Additional comments on GBEP hearings.

ref: GBEP-IP059

B1241, Kexby Lane South
 Scale - 1:1000

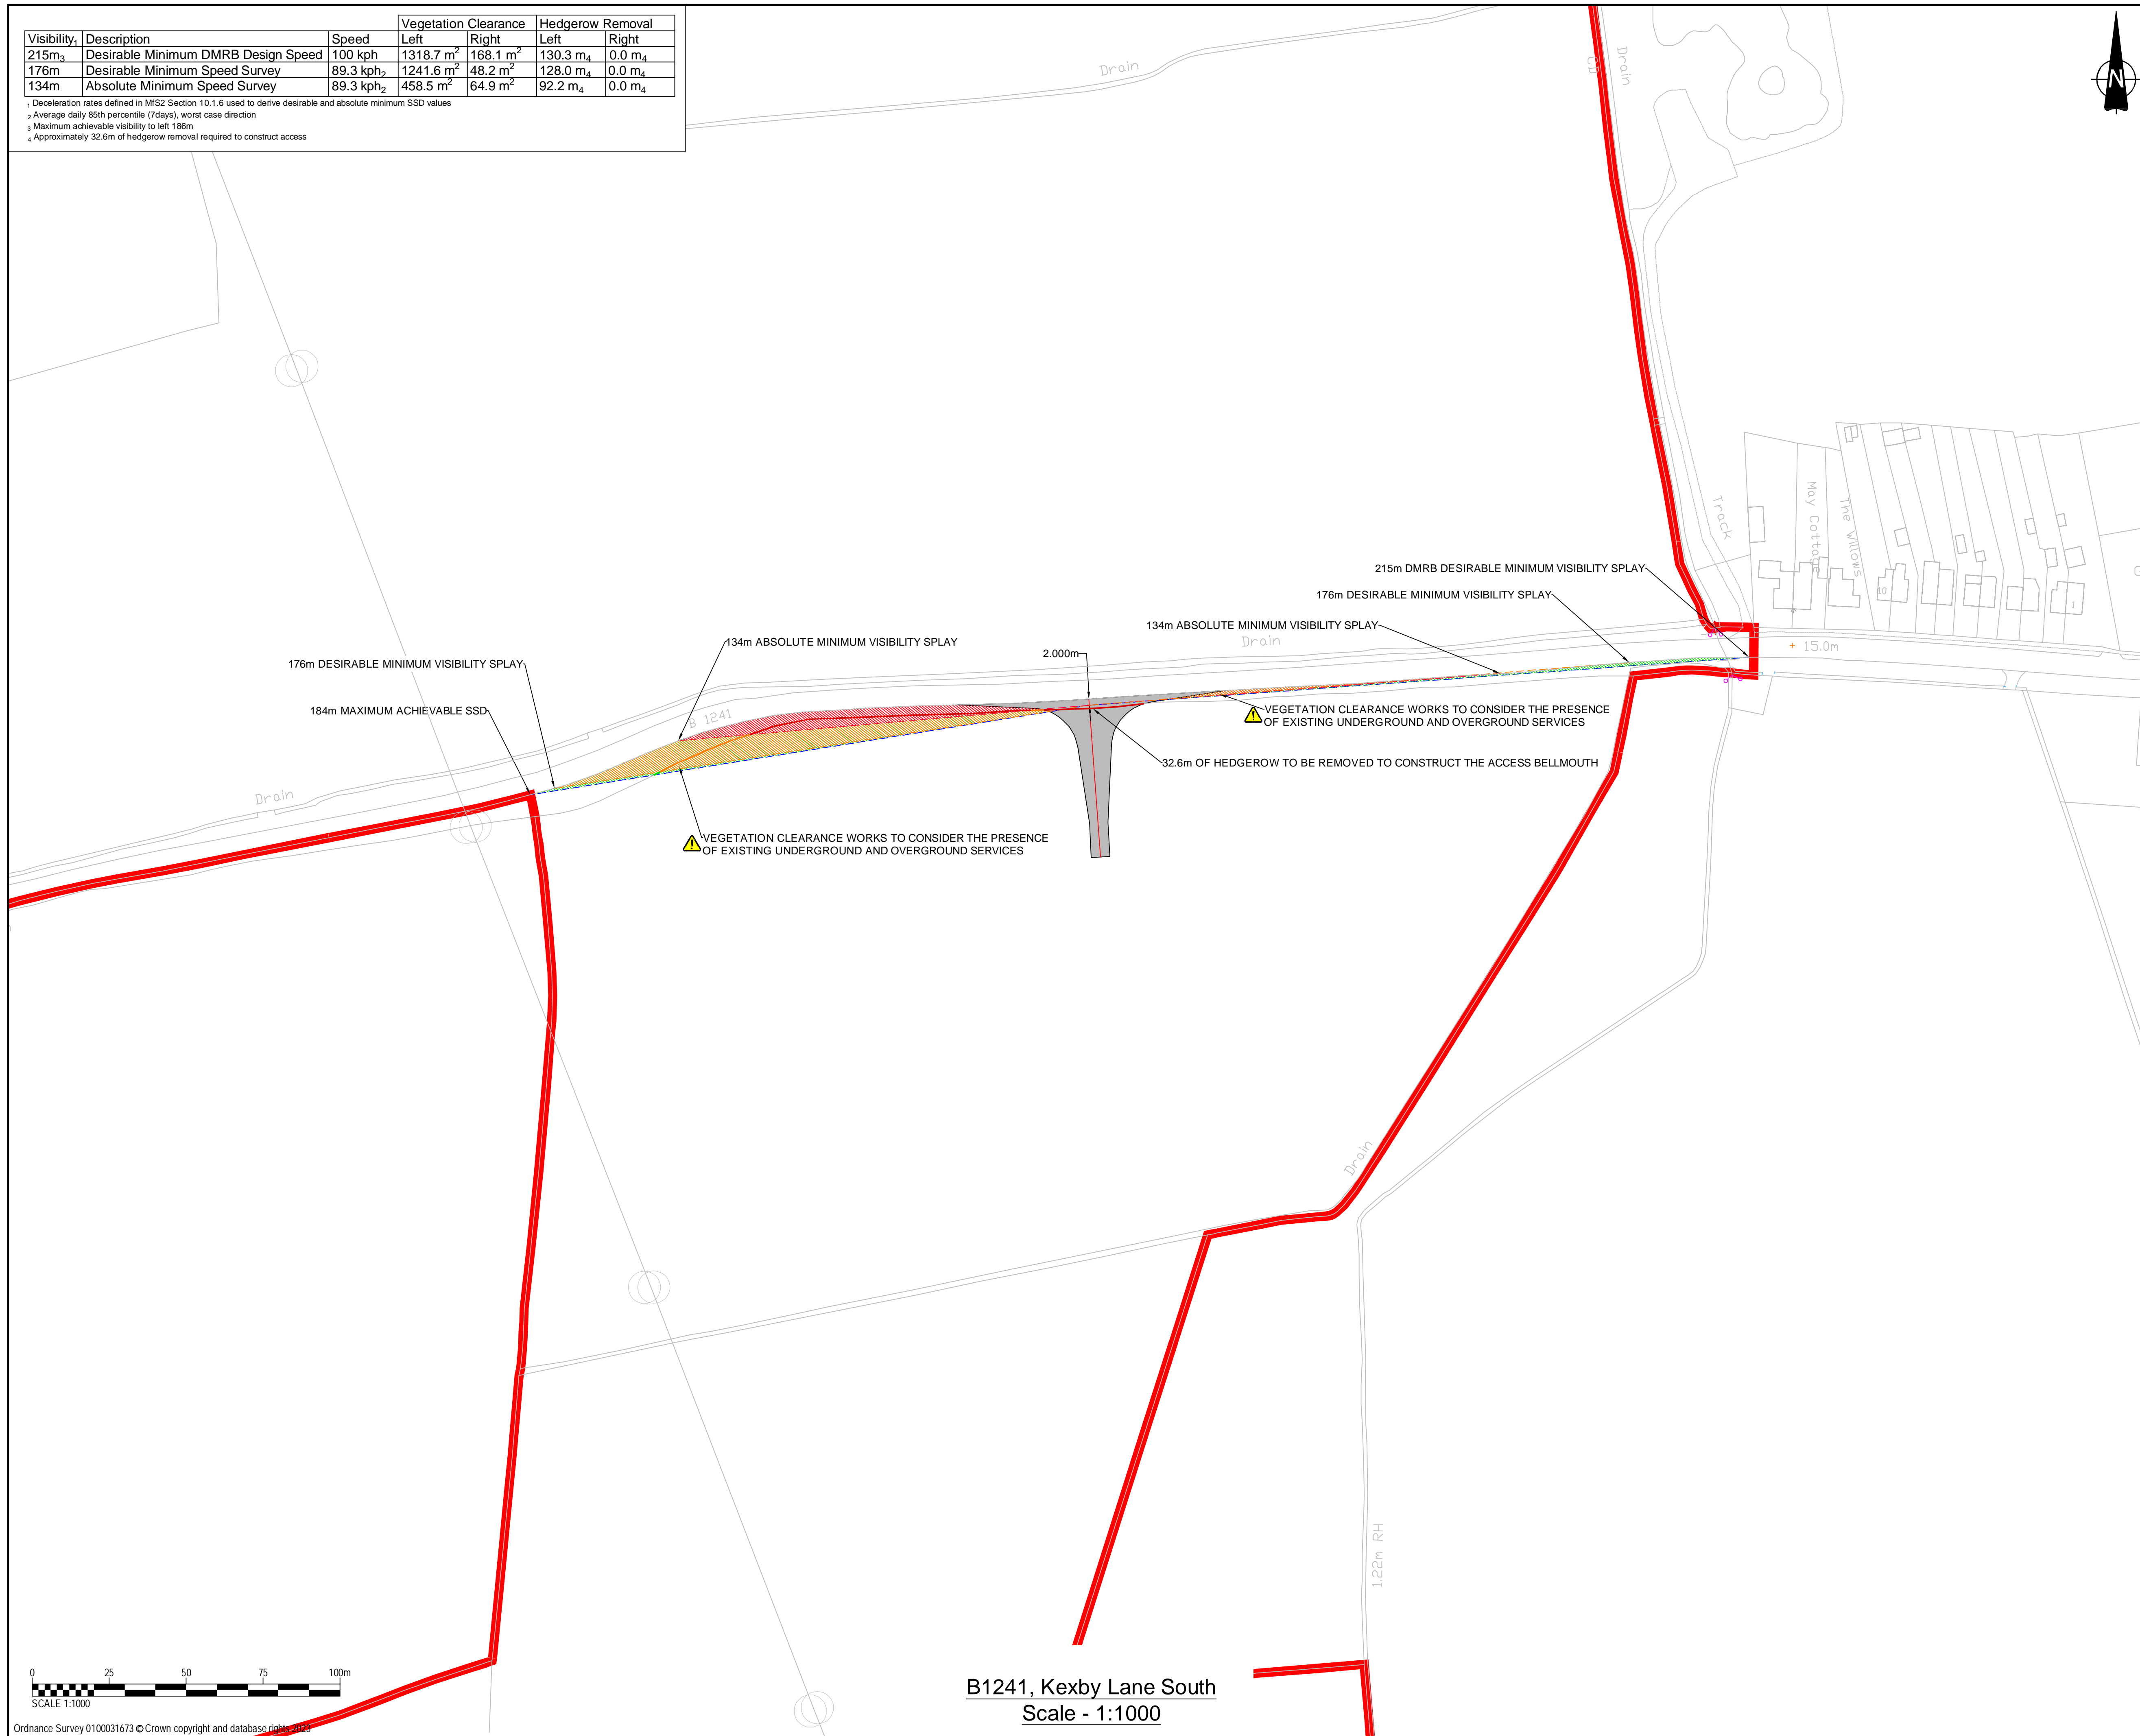
- 2. Construction sites on Kexby Lane (B1421) The siting of the construction site south on Kexby lane is in very close proximity to residential properties & businesses. The business attracts numerous vehicles almost daily dropping off and picking up animals. parking on the road is often necessary. Residential properties will have their way of life impacted with circa 110 vehicle trips in and out daily. Noise, spoil and detritus matter from the site deposited on the roadway, airborne dust and fumes 12hours plus daily.**

The siting will require the destruction of part of a wood, (some of which provides a screen to the sewage pumping station). The destruction of an ancient hedgerow which is home to many species of bird, insect and small mammals.

There is an existing opening into the field some 125m further West, this would also give a better field of view along the road to the East for exiting the site, this would reduce the amount of hedgerow & tree removal, it would also lessen to some extent, the impact on residential properties.

With that in mind there is a culvert that passes under the road allowing 3 ditch drains to flow into the Upper Witham river. One runs along adjacent to the doomed hedgerow and the proposed entrance to the Kexby Lane South construction site, this would need to be bridged.

The proposed construction site there raises concerns that building drainage, equipment, fuel stores etc. and hard standing runoff will be directed into the water courses here exasperating the potential for flooding and allowing contaminates to enter the marine environment. It is far to close to this drainage junction.
